Scottish Whitefish Producers Association Ltd
Fraserburgh Business Centre
South Harbour Road
Fraserburgh
AB43 9TN

Interested Party Reference Number: 20047990
Email: monaoffshorewindproject@planninginspectorate.gov.uk

On behalf of the Scottish Whitefish Producers Association Ltd referred to further in this response to the Mona proposed offshore windfarm application as the SWFPA.

Outline Fisheries Liaison and Co-Existence Plan (J10)

Figure 1.3: Indicative location of Scallop Mitigation Zone.

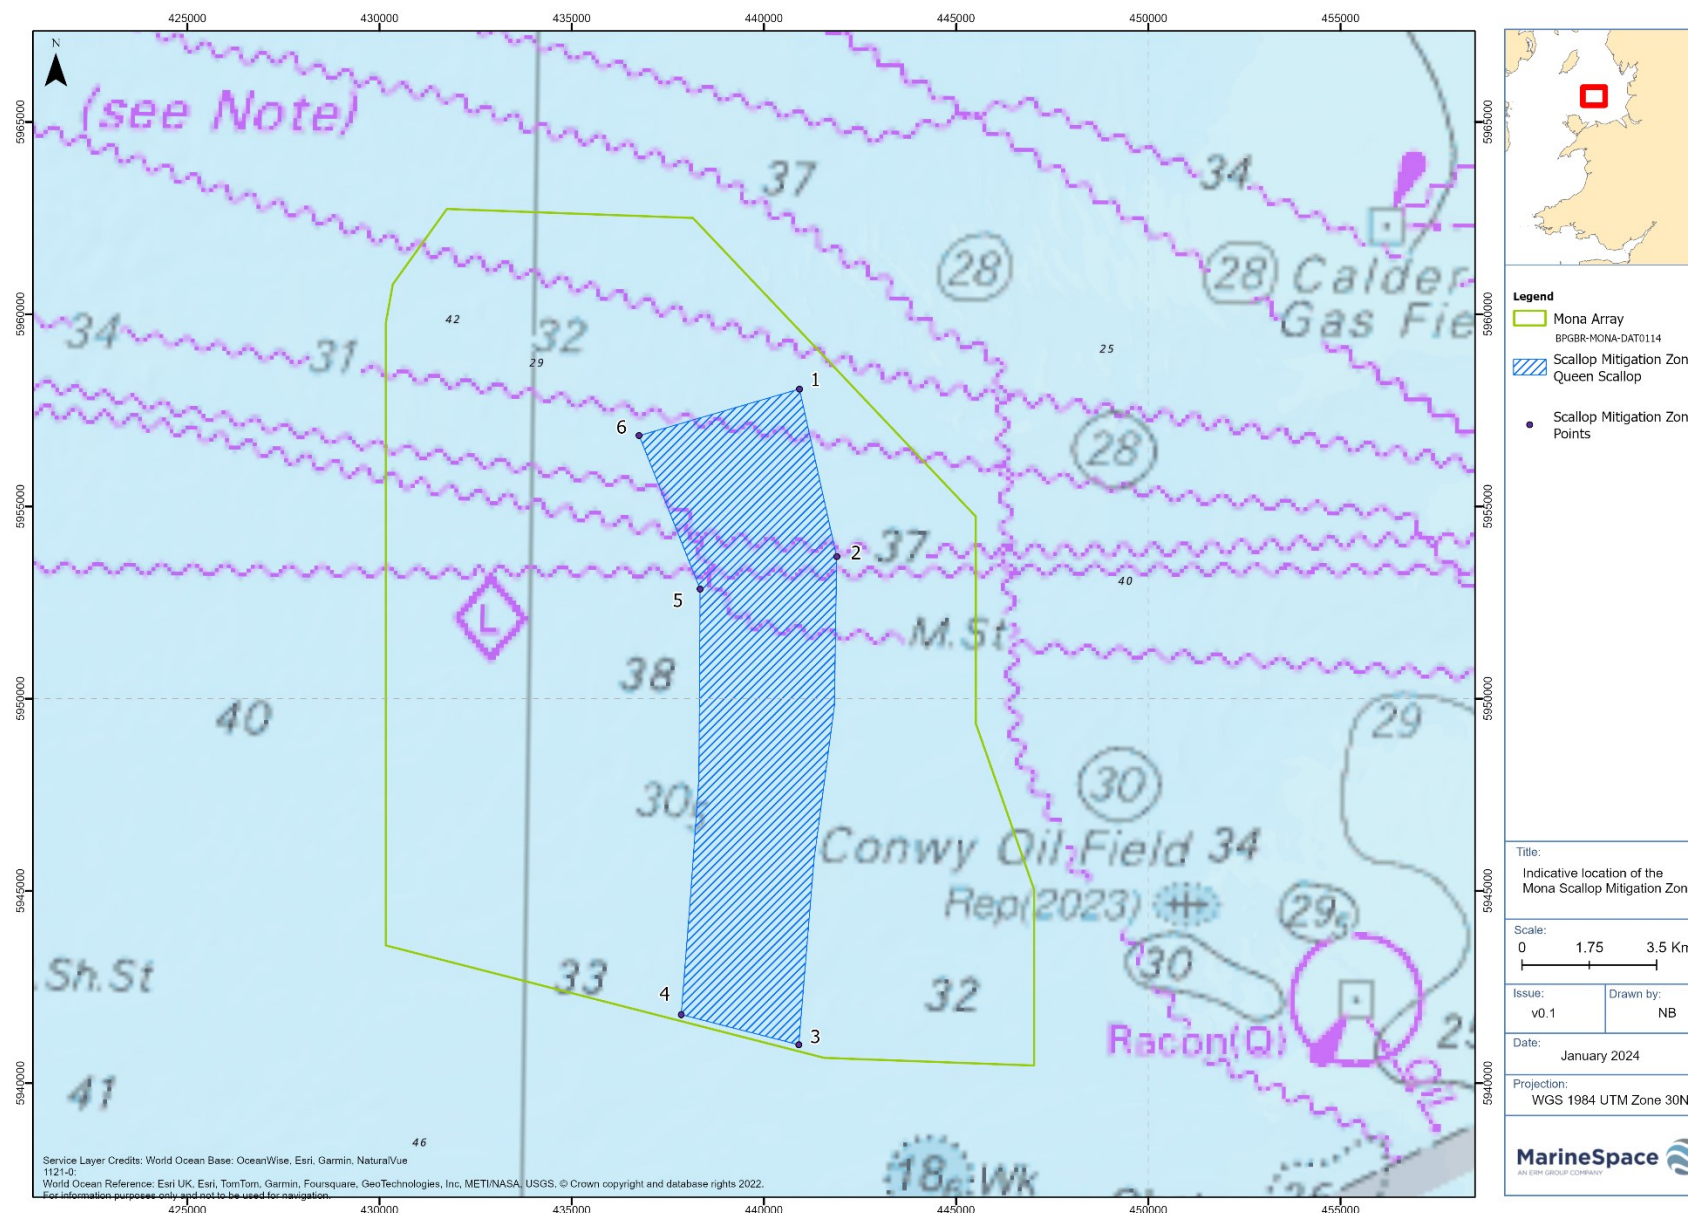
An additional concern of the FLCP is the SMZ, which, based upon the WCSP providing coordinates to the applicant, the SMZ corridor as it stands is some 3.2km in width, however is only circa 35% of what was communicated to the applicant. It is also noted that the SMZ is indicative, the SMZ could be reduced further.

Our understanding of the draft FLCP and the SMZ has been reduced because the developer chose not to utilize the eastern extents of the original lease area due to poorer wind yields. Given that there are operating windfarms to the east of Mona and should the applicant have developed to the East, the Mona array would not have encroached upon valuable fishing ground.

The Mona array and the export cable corridor (ECC) to the South shall be situated on circa 40% of 2023's fishing activity. In examining the SMZ detailed in the FLCP the net impact would mean that circa 30% of 2023 fishing activity for Queen Scallop fishing would fall within Mona not covered by the Scallop Mitigation Zone (SMZ).
